**RE: Urban Design Review Panel Report – 77 Metcalfe Street**

77 Metcalfe Street  
Response to UDRP Recommendations  
Site Plan Control Application

GROUND FLOOR - SITE PLAN
1:100

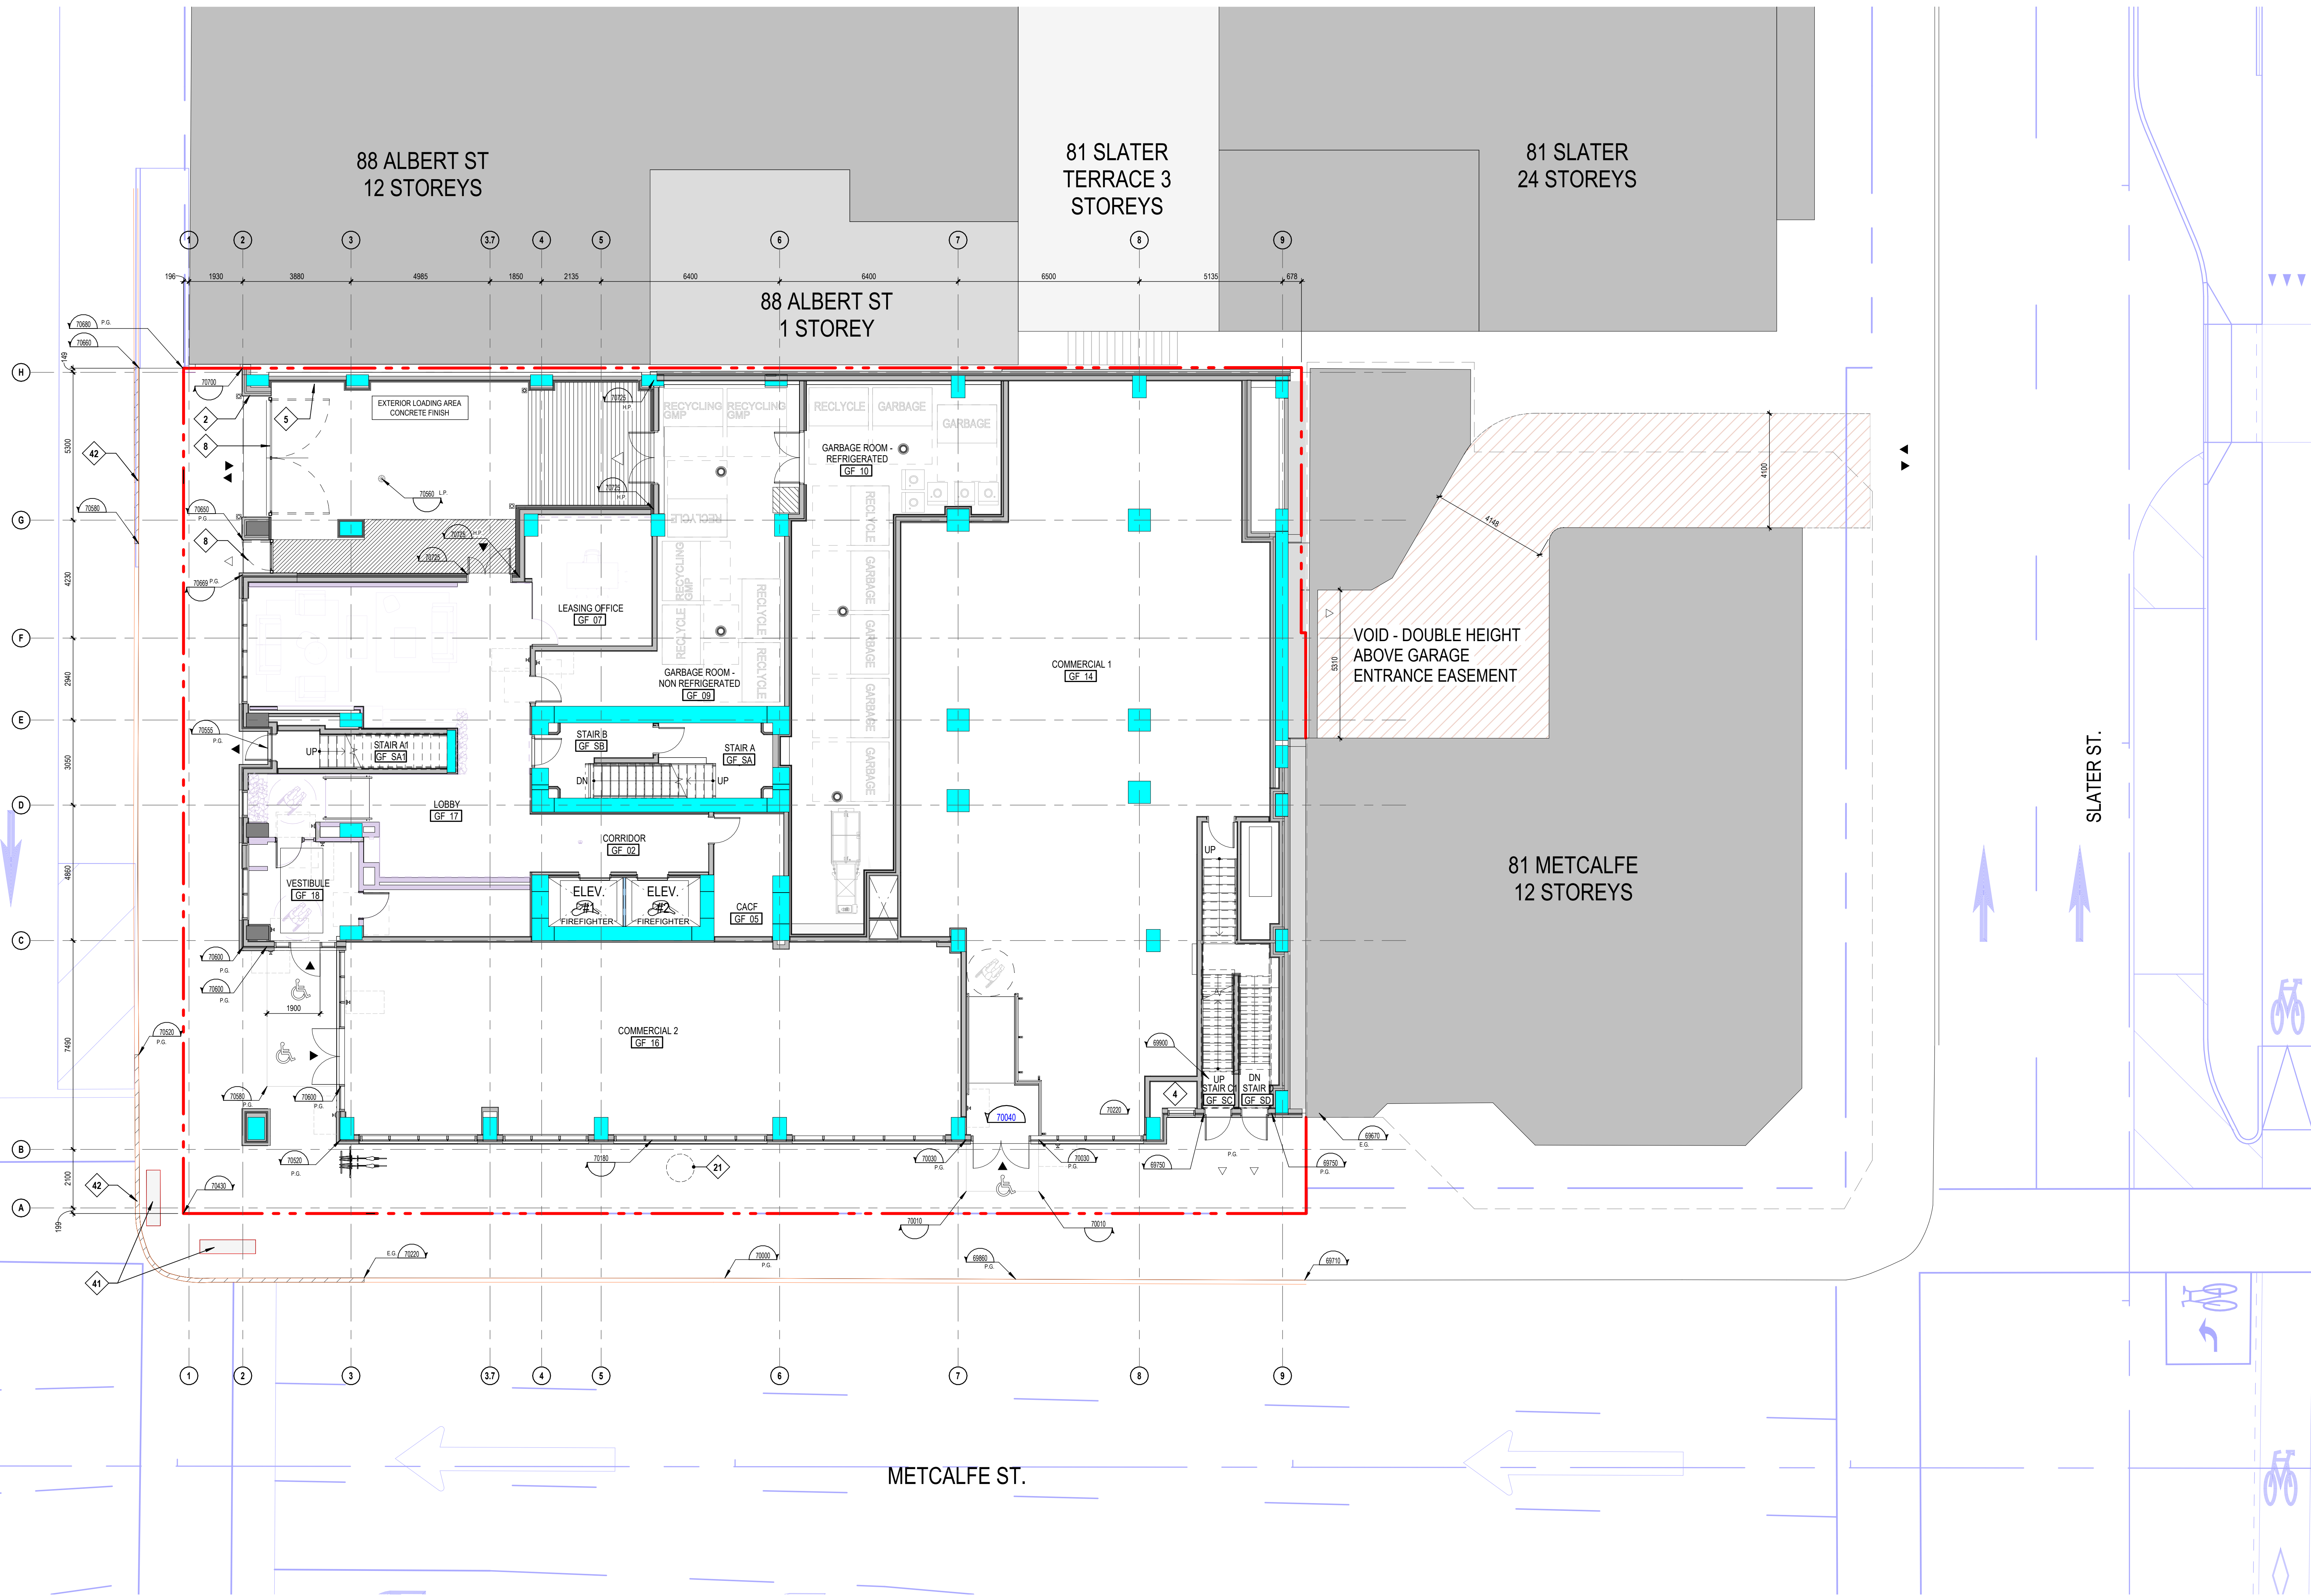
13	The Panel appreciates the integration of architectural elements but encourages more consistent detailing, particularly in the interface between the building and the public realm.	Noted. As previously noted, the revised design incorporates a simplified building expression, including at grade.
14	The Panel suggests improving the ground floor layout by reconfiguring the entry and lounge areas. Reversing these spaces would allow the entry area to better support movement and circulation.	Noted.

14.1	The Panel notes that the placement of the exit stair currently divides the lobby into two separate zones, disrupting the flow of the space.	Noted.
15	The Panel suggests reconsidering the programming of the corner space to bring activity to the area throughout the day and night, potentially incorporating an amenity space that contributes to the building's liveliness and integration into the neighborhood.	Noted.
